MEMORANDUM

From: Steve Long
To: Jean Fraser, Planner
Date: ~~December 4, 2012~~, **Revised 01-02-13**
Subject: Commercial & Maple Street Mixed Use Development – Responses to Comments

Department of Public Services comments dated 11/07/12

Woodard & Curran Comments dated 11/06/12

STORMWATER PLANTER PLAN  
SCALE: 1 INCH = 3 FEET

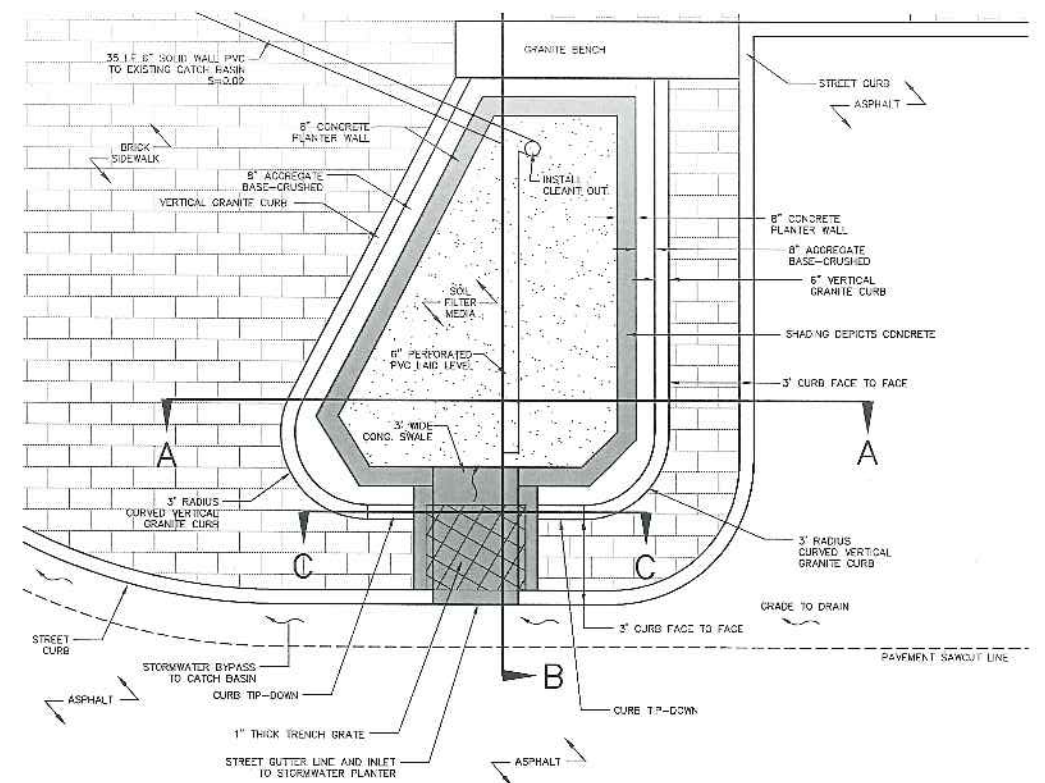
3. It would be desirable to use portion(s) of the proposed bump outs for green area stormwater treatment.
A green area stormwater treatment area is now being proposed within the bump out at the Commercial Street site entrance. Please see attached plan showing the treatment area and the area to be treated.
01-02-13 Response: A stormwater planter is now being shown in the proposed bump out at the intersection of Commercial Street and Maple Street.

b) General Standards: The project primarily includes re-development of existing impervious areas. However, the project does include 2,513 square feet of new impervious area. Redevelopment of the existing impervious areas of the site qualifies for an exemption from meeting the General Standards; however, the Applicant must provide stormwater treatment in accordance with the General Standards for an area equivalent to the proposed 2,513 square feet of new impervious area. Inspection and maintenance of any proposed stormwater quality treatment features will need to be included in the Inspection and Maintenance Plan in accordance with and in reference to Maine DEP Chapter 500 guidelines and Chapter 32 of the City of Portland Code of Ordinances

01-02-13 Response: A stormwater planter is now shown in the proposed bump out at the intersection of Commercial Street and Maple Street. Please see the Construction Details, sheet C11 for the details plan and sections. The treatment area is approximately 4,000 square feet. Inspection and maintenance of this stormwater planter has been added to the Inspection and Maintenance portion of the Storm Water Pollution Prevention Plan.

DATE: 10-22-12  
 SCALE: 1"=20'  
 DRAWN BY: BJS  
**C04**  
 SHEET: 4 OF 14

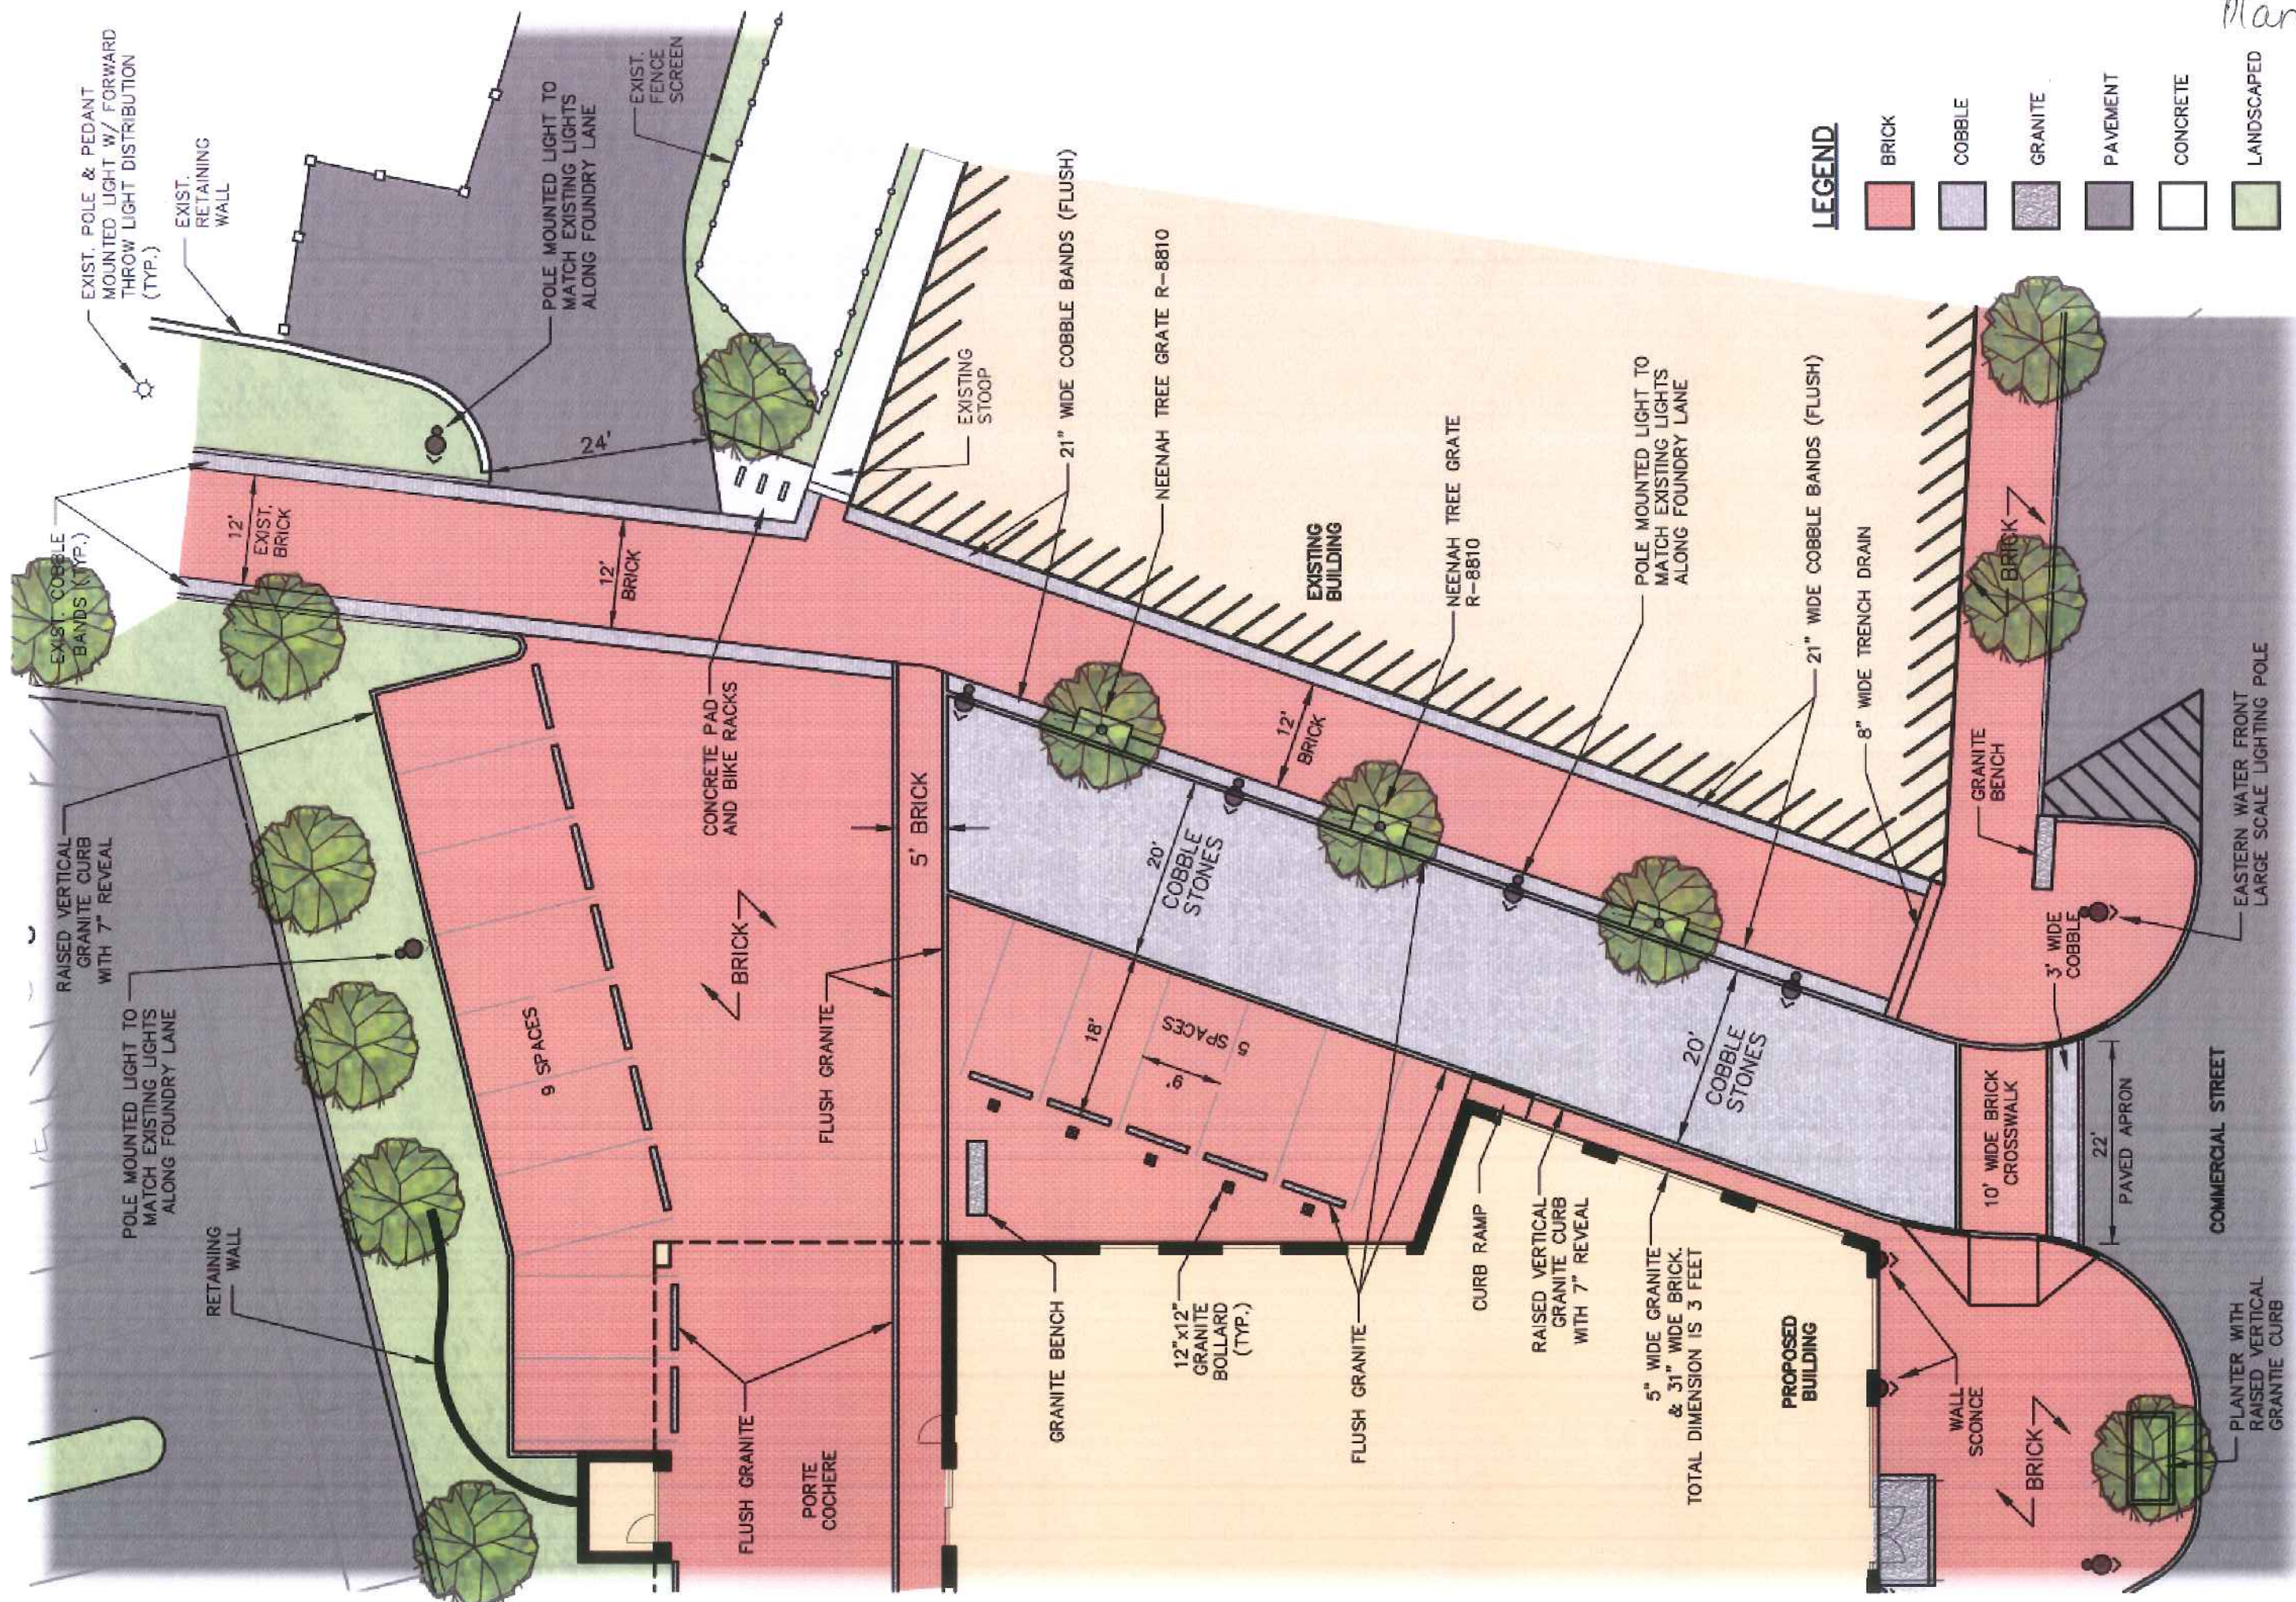
- Submit signage and way finding plan.
A signage and way finding plan will be submitted at a later time.
01-02-13 Response the same as above.
- Submit further information including capacity letters, service vehicles, and snow storage
Frank Brancely in Public Services is currently reviewing our application for wastewater capacity. All other capacity letters have been submitted. A location for service vehicles and deliveries along with notes addressing snow storage will be added to the final plan set.
01-02-13 Response: Notes #1 and #6 are provided on the Site Plan, sheet C04 to address deliveries and snow storage.
